**KIRKLEES METROPOLITAN COUNCIL
INVESTMENT & REGENERATION SERVICE**

**DELEGATED DECISION FOR DISCHARGE OF CONDITION A1 -
NOTIFICATION OF A PROPOSED DEVELOPMENT UNDER LOCAL OR
PRIVATE ACTS OR ORDER**

Reference no. 2023/CL/91857/E

**Site Address Dewsbury Railway Station,
Wellington Road, Dewsbury,
WF13 1HF**

Prior Approval
Dewsbury Station
Proposed Canopies Details

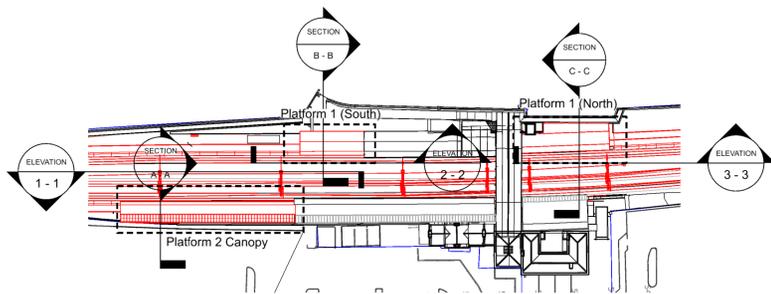
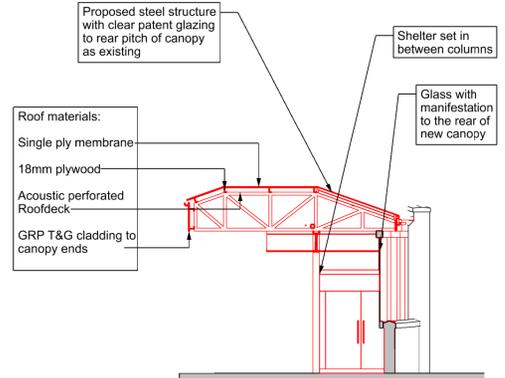
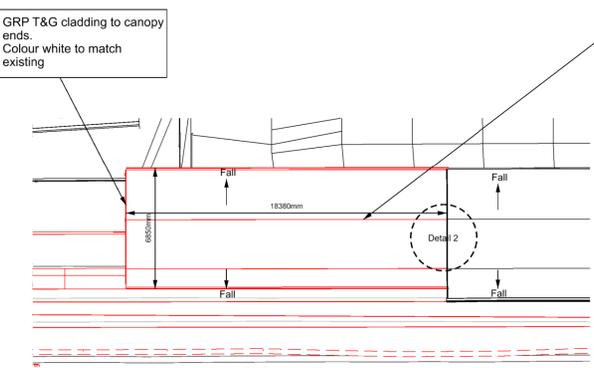
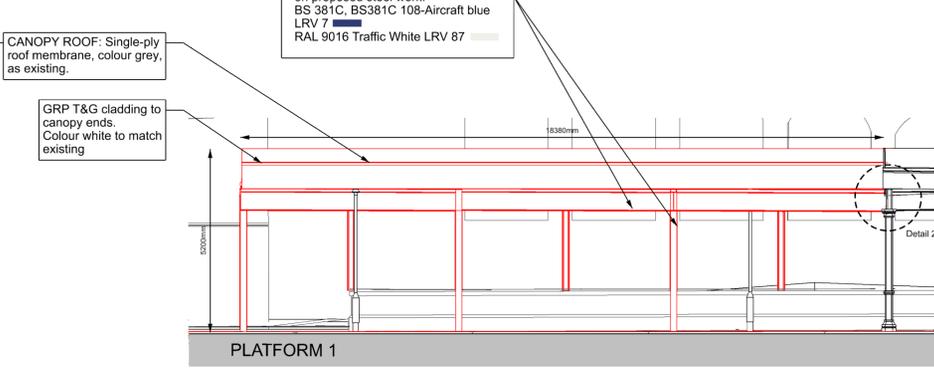
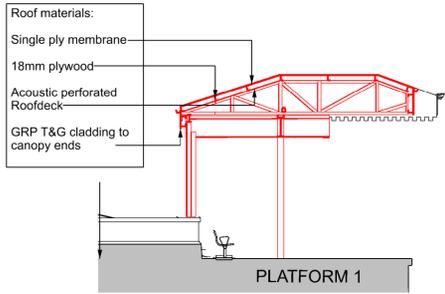
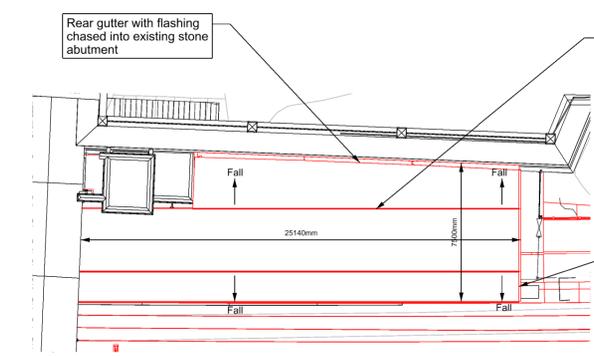
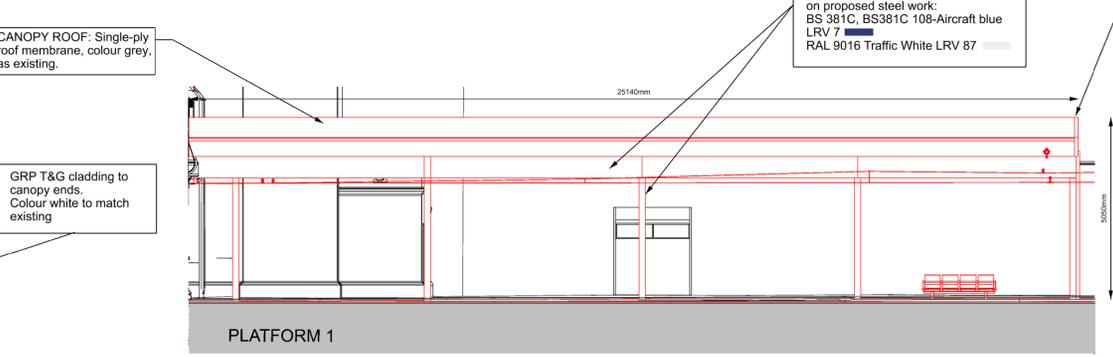
The proposal seeks to extend the canopies to comply with operational standards and to provide an enhanced station environment, encouraging passengers to use the entire platform in inclement weather, as well as improving passenger comfort and safety by providing additional shelter. A large section of the canopy on Platform 1 was removed in the late 20th century, with a 40m length surviving, whilst most of the 1880's canopy still survives along Platform 2.

In the Heritage Statement submitted with the Listed Building Consent application, it is noted various options were considered with regards to the lengths of the canopy extensions and column positions. The Conservation and Design officer has previously concluded that the canopy lengths are justified as they will improve passenger comfort and safety on the platforms with no harm to the historic fabric or the existing structures. The extensions will take design cues from the existing, albeit with simpler detailing so that they can be distinguished from the historic canopies.

The proposed columns are set further back further from the platform edge than the existing, creating a staggered line which will disrupt the rhythm of the historic column positions and spacings. Ideally the new columns would follow the line of the existing to provide continuity, however current accessibility design standards require a minimal distance between structures and the platform edge, so the columns need to be set back further than the existing.

The design of the proposed canopy structure on Platform 2 responds to the existing, taking cues from the architectural form while using a contemporary approach that allows the historic elements to remain legible. The proposed canopy on Platform 1 reinstates a historic canopy that had previously been removed, with similar detailing and form. The Conservation and Design section raise no objections.

5. Prior to the canopy extensions being installed, the detailed design of the columns and column connections for the canopy extensions on Platforms 1 and 2 shall be submitted to and approved in writing by the Local Planning Authority. Thereafter the development shall be undertaken in accordance with the approved details and be retained.

Drawing Title  
**Prior Approval  
Dewsbury Station  
Proposed detail of treatment  
Rear of Platform 2**

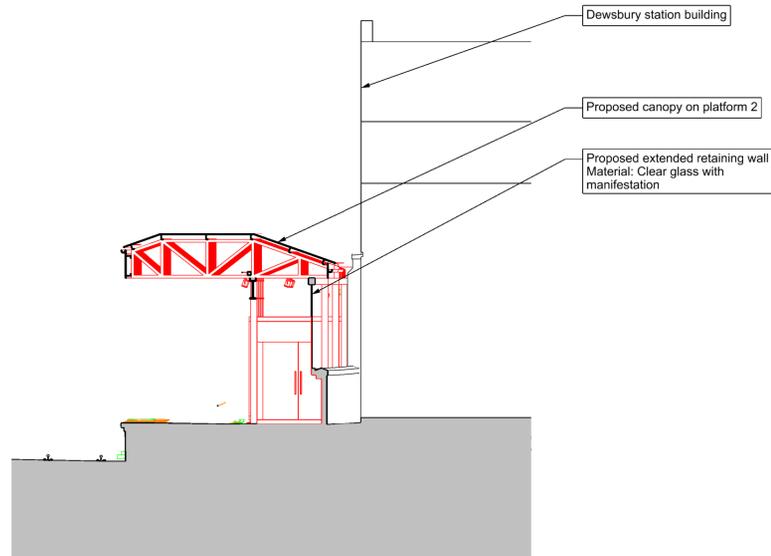
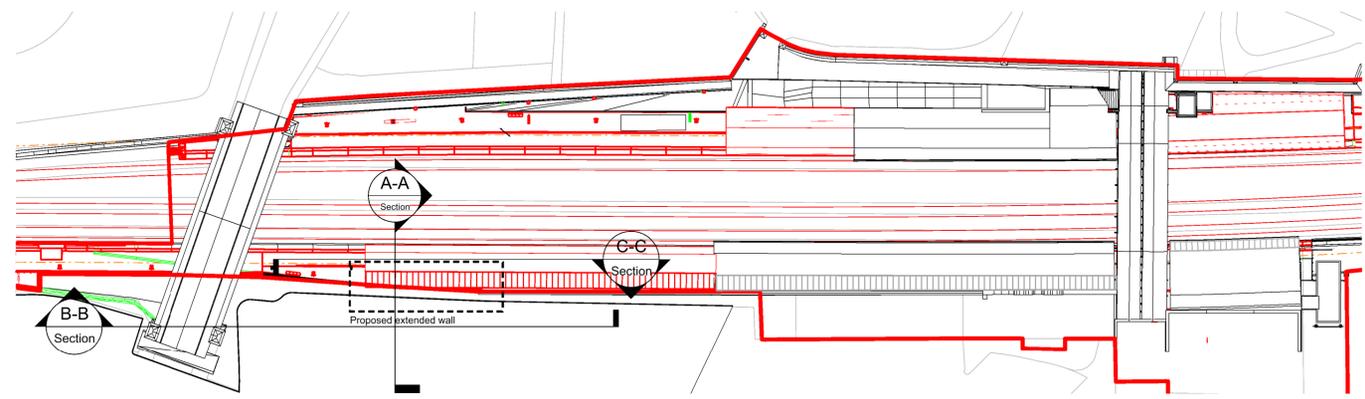
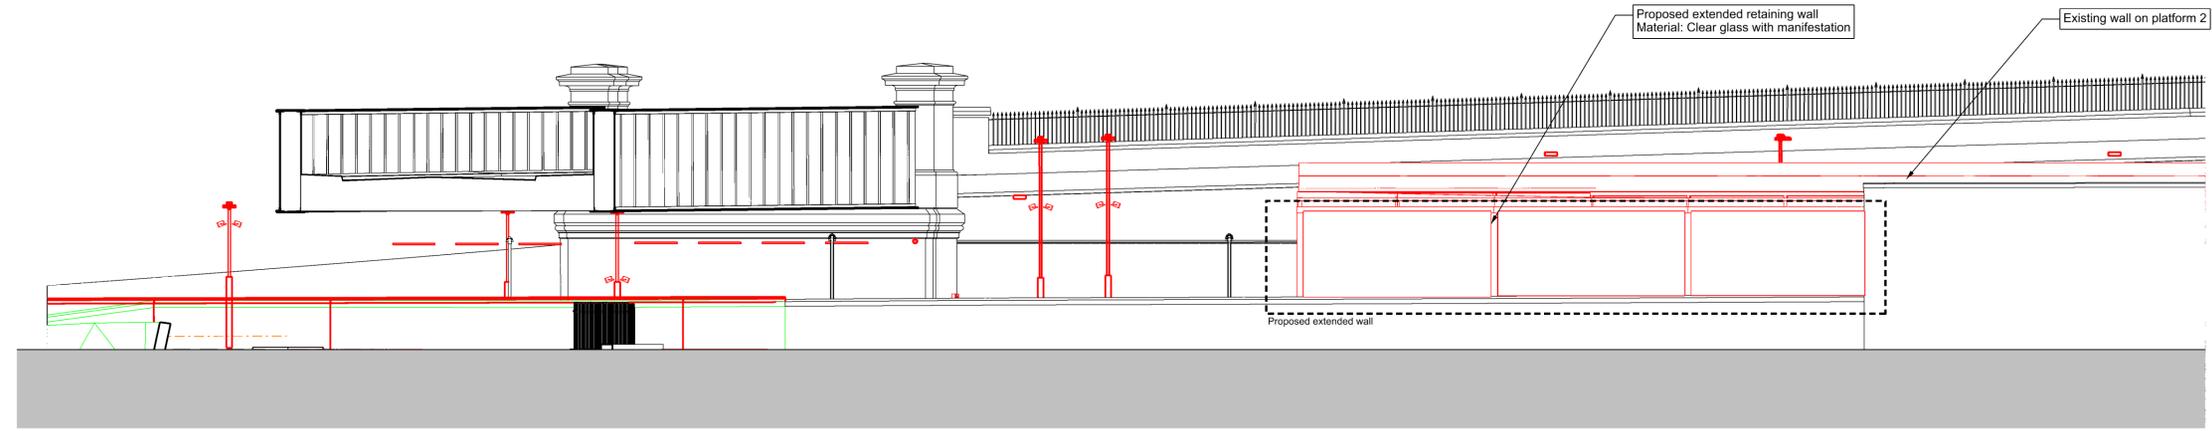
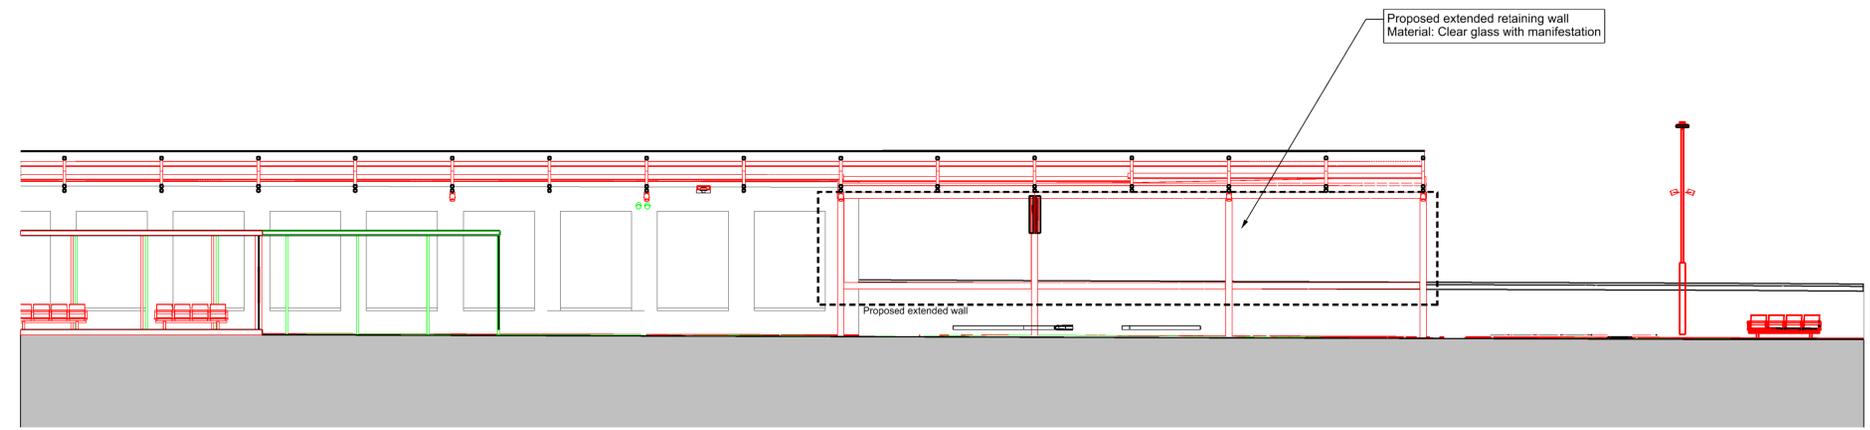
A glazed screen with etched artwork is proposed to the rear of the extended shelter and following the line of the historic stone wall of the original station building. Concerns have been previously raised by Conservation and Design about its maintenance and the visual impact on the character of the conservation area and therefore simple metal railings were suggested instead. A condition was applied requiring details of the screen to be submitted for approval and it is considered appropriate to repeat this condition in the interest of securing appropriate design and to protect amenity of the neighbourhood.

2. Notwithstanding the information submitted, no work shall take place to install the proposed wall-top barrier between Platform 2 and the station car park until full details of the proposed barrier have been submitted to and approved in writing by the Local Planning Authority. Details shall include scale drawings showing the design, materials, colour and fixing methods of the barrier. Thereafter the proposed barrier shall be undertaken in accordance with the approved details and be retained.

Drawing Title
**Prior Approval
Dewsbury Station
Proposed Enclosure Details
Footbridge**

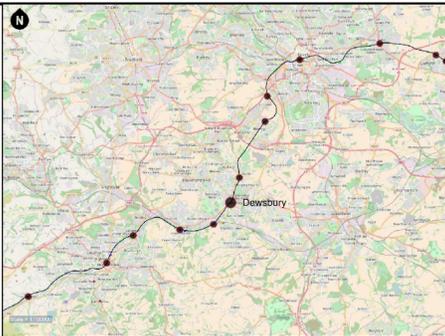
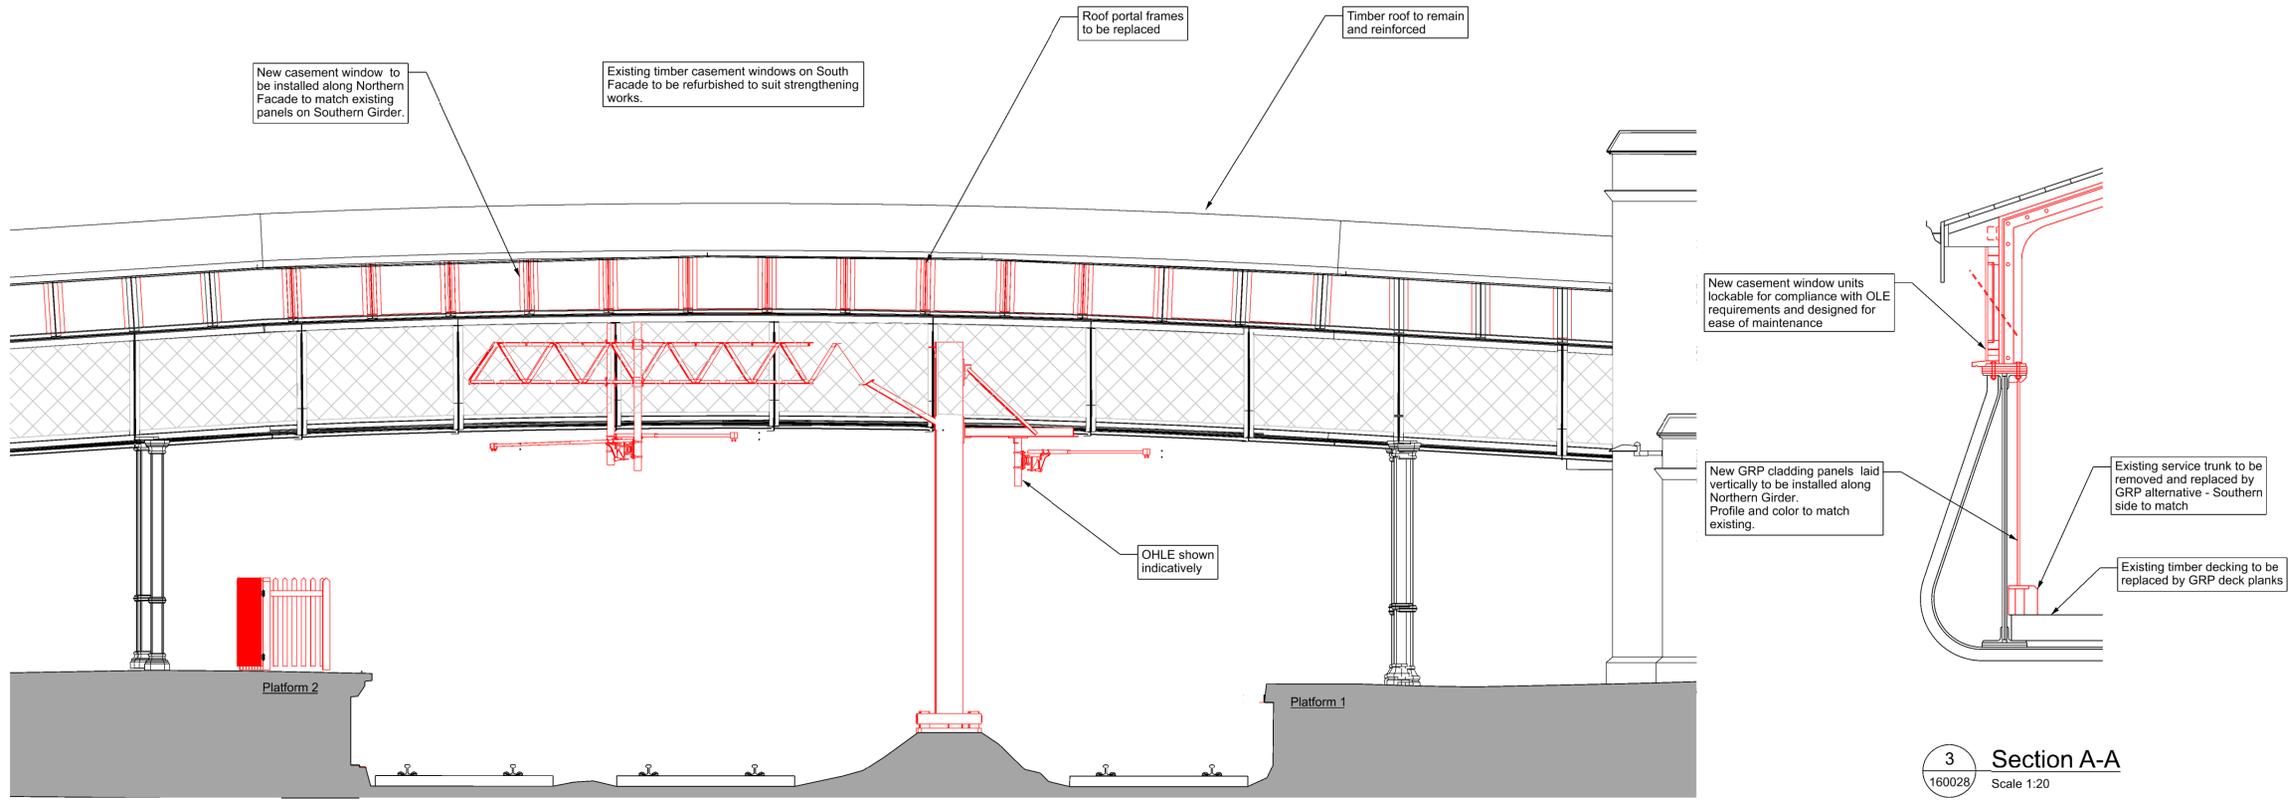
The existing footbridge is a wrought iron structure with an iron portal frame and a lattice web connecting the main structural chords. The deck, canopy and window frames are in timber and the deck is surfaced in a modern non-slip membrane. The south elevation incorporates windows along the footbridge, while the north elevation is open sided. The statement of significance submitted with the Listed Building Consent states that there were originally windows on both sides of the footbridge, with the windows on the Leeds side removed in 1988. The proposal seeks to reinstate windows on this elevation in the same design and materials as the late 19th century windows on the south elevation. This will comply with safety requirements to ensure that the OLE installation cannot be reached from the footbridge and will also reinstate a historic detail.

Strengthening of the footbridge is also proposed to comply with safety standards. This includes the replacement of roof portals with more substantial

sections in the same design, incorporating structural GRP panels within the roof structure and steel plates to strengthen the lattice truss girders. Conservation and Design section have previously concluded that the replacement of historic sections and introduction of modern materials will lead to less than substantial harm to the significance of the structure. However, these interventions are discreetly placed and based on recommendations following a structural assessment, in which strengthening and stabilising the structure are justified to ensure its longevity and to remain in use. The design, detailing and colour palette will replicate the existing to minimise the harm.

The flooring will be in waterproof GRP with a non-slip finish, with the underside of the footbridge and steelwork painted in a resistive coating to prevent electric conductivity.

Drawing Title **Prior Approval Dewsbury Station Proposed General Arrangement**

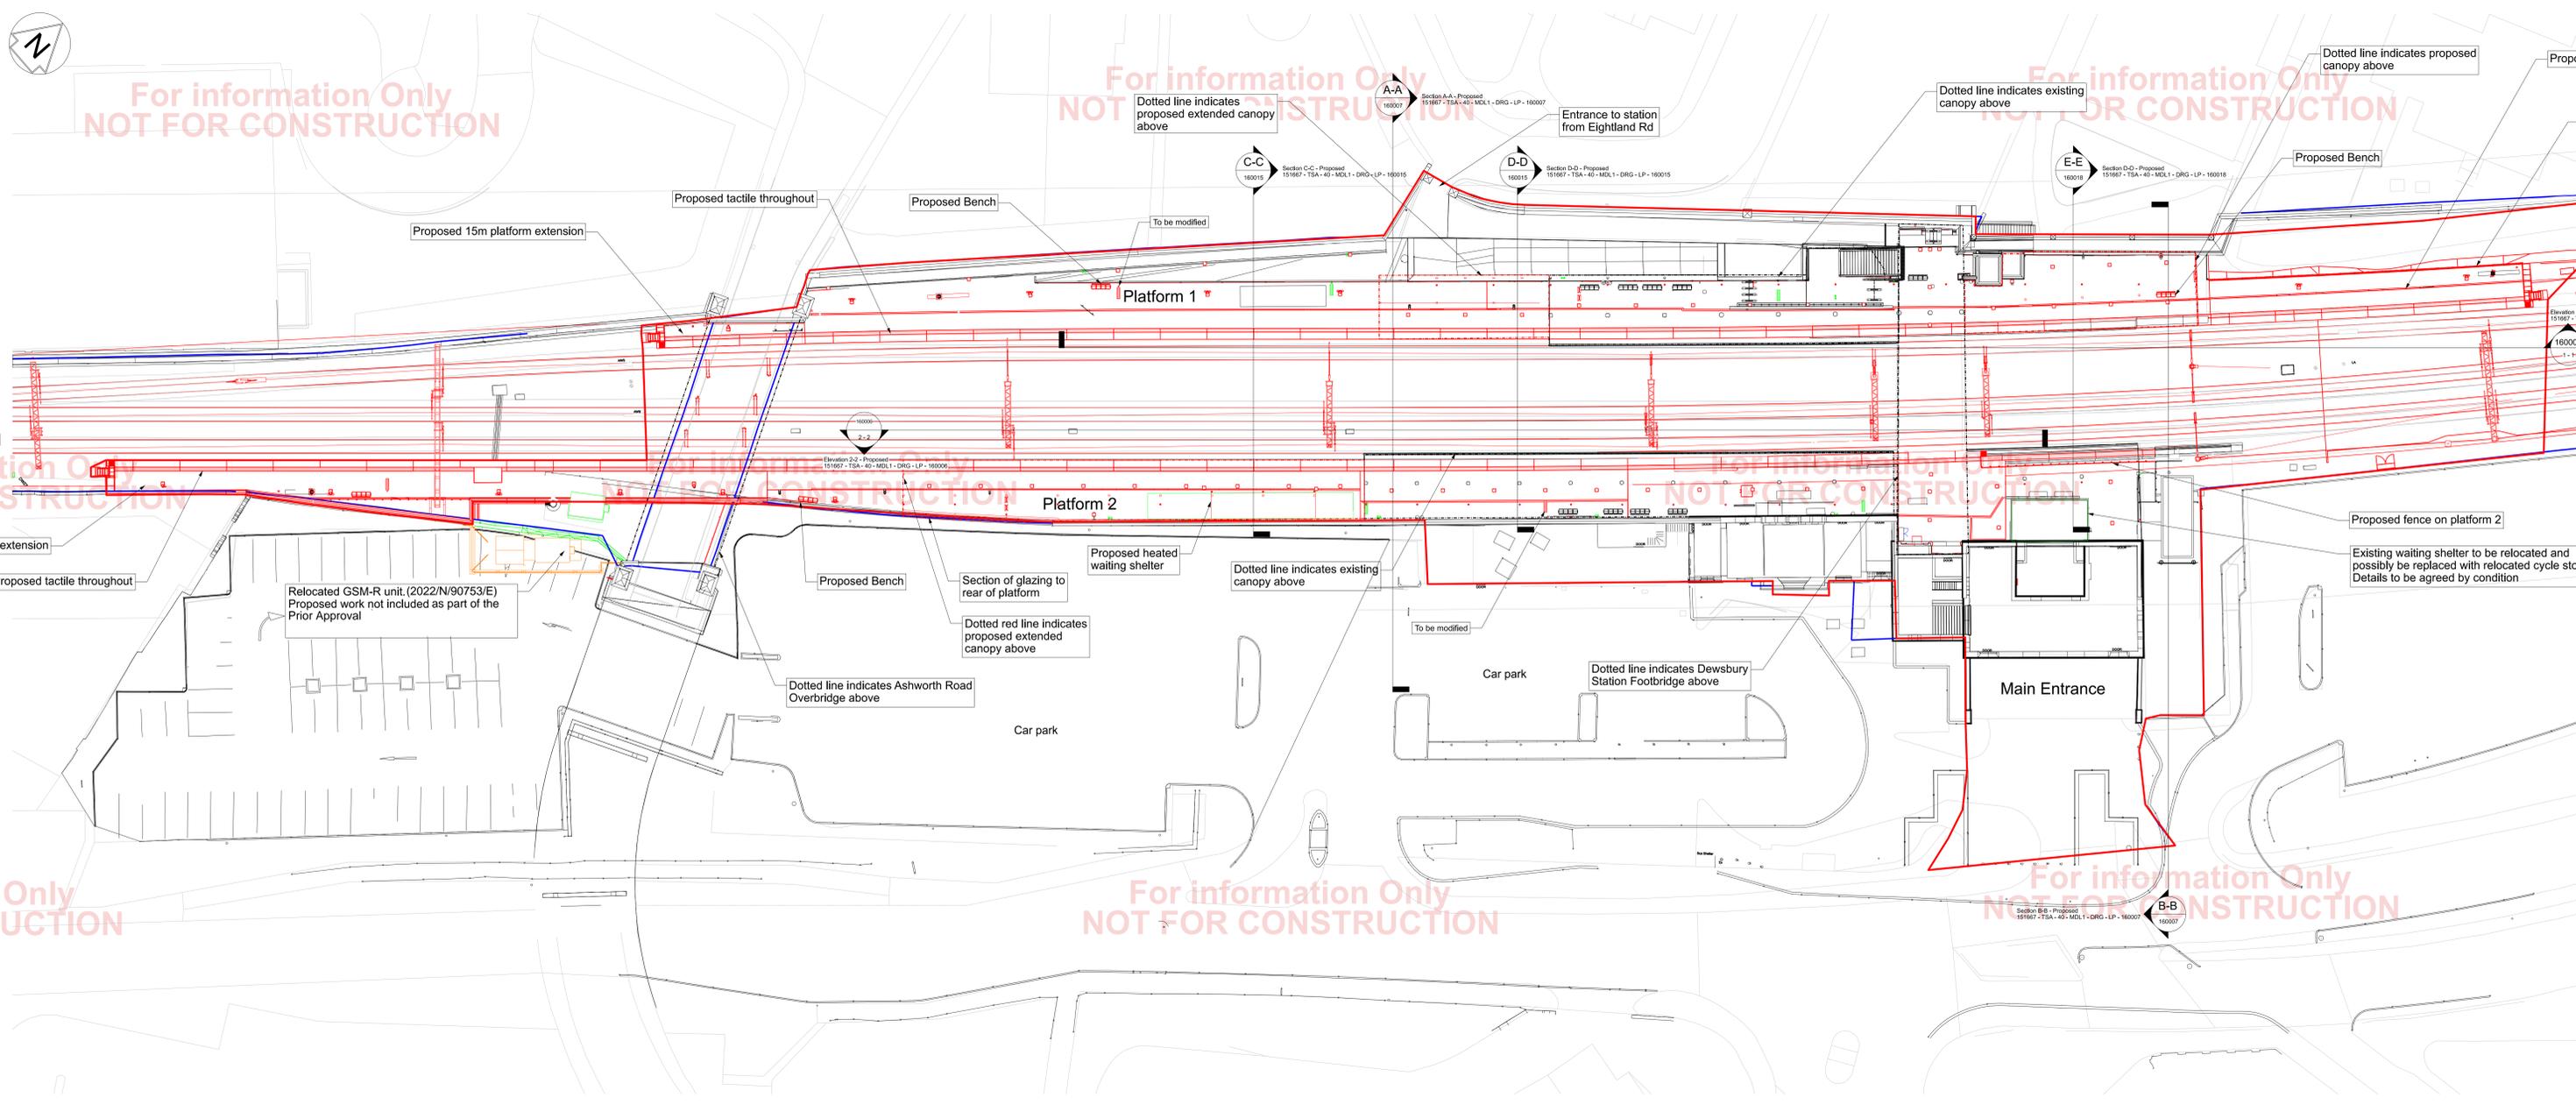
The proposal is to extend the station platforms to accommodate longer rolling stock. The masonry of the proposed platform extension walls will be in pre-cast concrete units with stone slip cladding to match the existing, with the platform extensions finished in GRP surfacing. Conservation and Design have previously concluded in the granted listed building consent application for the works that the historic surfacing is no longer evident, and the proposed surface will provide a safe, non-slip surface which is an acceptable proposal. They concluded the public benefit of providing improved facilities at the station outweighs the slight harm caused by alterations to the historic platforms. As part of the Listed building Consent a condition was imposed to ensure that the historic string courses are retained, this condition will be repeated in the interest of securing appropriate design and to protect amenity of the neighbourhood.

3. The stone string courses which form part of the platform retaining walls, and the platform ramps themselves, shall be retained, including the sections which taper towards the ends of the existing platforms. New masonry for the construction of the extensions shall incorporate these string courses and the ramp formations, to allow the historic platform detailing and lengths to remain legible.

4. Prior to works commencing to the platform extensions, details and materials of the proposed paving, steps and fencing at the platform ends, shall be submitted to and approved in writing by the Local Planning Authority. Thereafter the development shall be undertaken in accordance with the approved details and be retained.
